**RE: Widefield Water and Sanitation District
Rolling Hills Tank 2 MG Potable Water Tank – Financial Assurance**

2019 Financial Assurance Estimate Form (with pre-plat construction)

PROJECT INFORMATION		
	2/8/2021	XX-XX-XXX
Project Name: Widefield Water and Sanitation District Rolling Hills Tank	Date	PCD File No.

**C7**  
 SHEET 10 OF 32

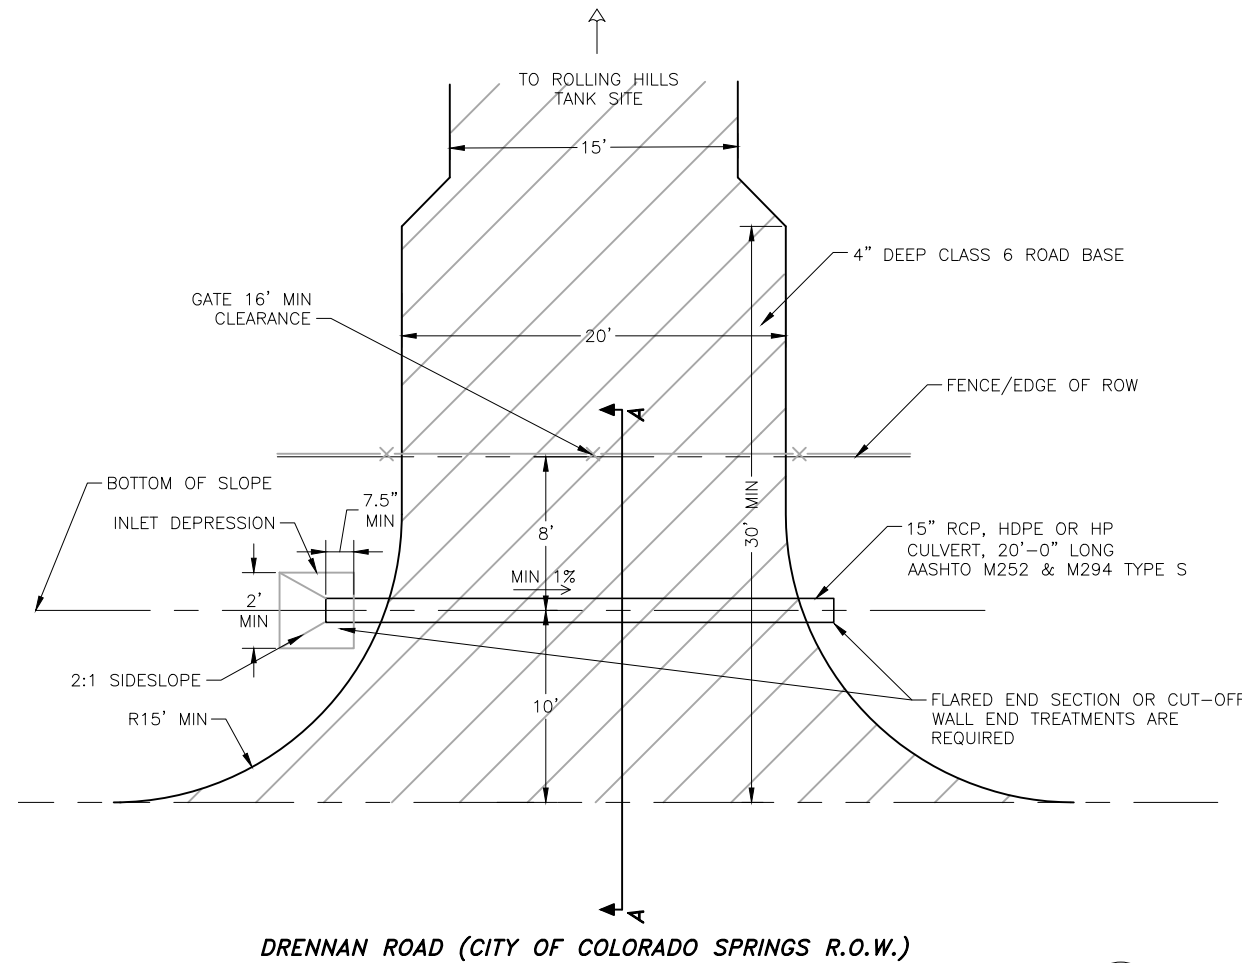
Please include the driveway culvert. Also please use the latest 2021 FAE form which can be found on the following website:
<https://planningdevelopment.elpasoco.com/planning-development-forms/#1516906638016-61792baf-6cf4>
